Hampshire Water Transfer and Water Recycling Project

Environmental Statement – Figure 8.3 Non-statutory designated sites within the desk study area

17 July 2026

Document Control		
Title	Environmental Statement – Figure 8.3 Non-statutory designated sites within the desk study area	
Version History		
Version	Date	Status/Reason for Issue
Version 0	21 May 2026	DCO Submission
Version 1	17 July 2026	S51 Advice

Figure 8.3
 Non-statutory designated sites within the desk study area
 Sheet 15 of 16

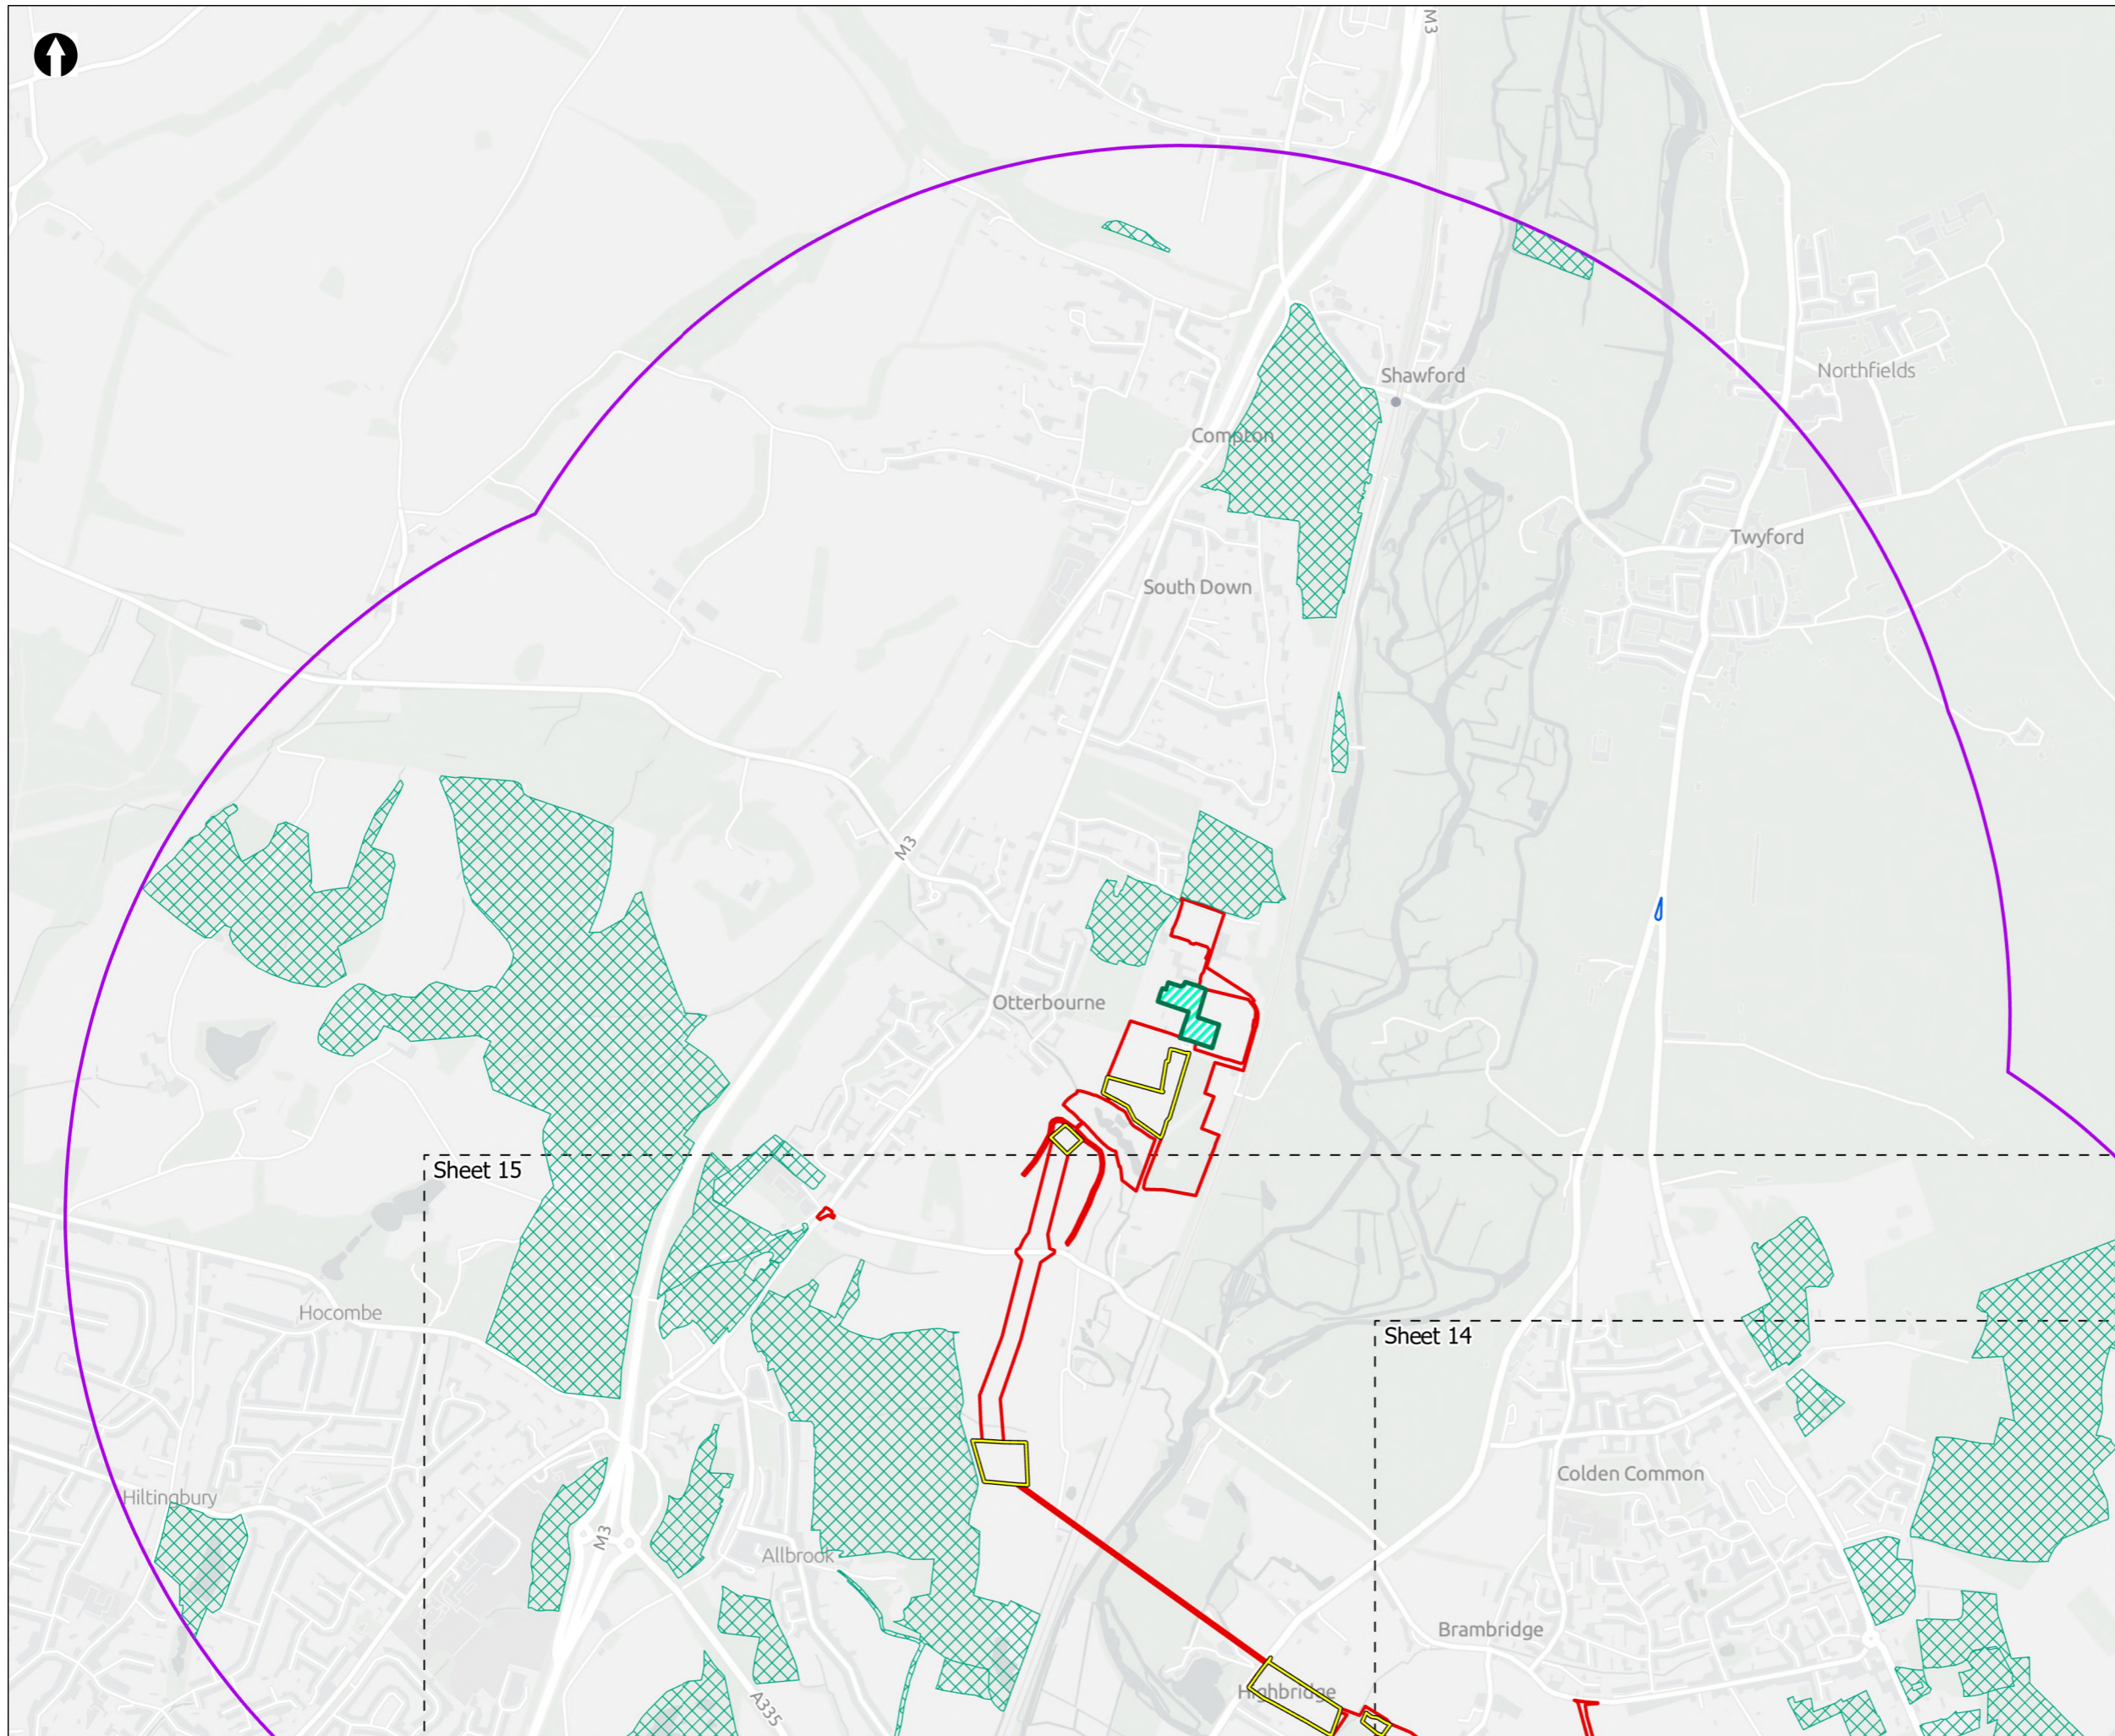
Drawing Number	Drawing Title	Updated Revision	Changes
PC5223-RHD-ES-ZZ-D-Z-0028	Figure 8.3 Non-statutory designated sites within the desk study area SHEET 15 OF 16	06	All SINC's and RVEIs included in the ecology assessment (ES Chapter 8) added to figure: • Gore Copse SINC • Chestnut Gully Wood SINC • The Mount Fair Oak and Horton Heath SINC • Fielders Farm Meadows (Eastleigh) SINC • Colden Common Wood and Bracknells Copse SINC • Stoke Park Wood SINC • Pitmore Copse/Pitmore Gulley Copse SINC • Pitmore Copse (West) SINC • Otterbourne Hill Common SINC • Otterbourne Primary School Meadow SINC • Long Mead SINC • Great Moorlands Copse Complex SINC
PC5223-RHD-ES-ZZ-D-Z-0028	Figure 8.3 Non-statutory designated sites within the desk study area SHEET 16 OF 16	06	All SINC's and RVEIs included in the ecology assessment (ES Chapter 8) added to figure: • Pitmore Copse/Pitmore Gulley Copse SINC • Pitmore Copse (West) SINC • Otterbourne Hill Common SINC • Otterbourne Primary School Meadow SINC • Long Mead SINC • Great Moorlands Copse Complex SINC • Shawford Down SINC
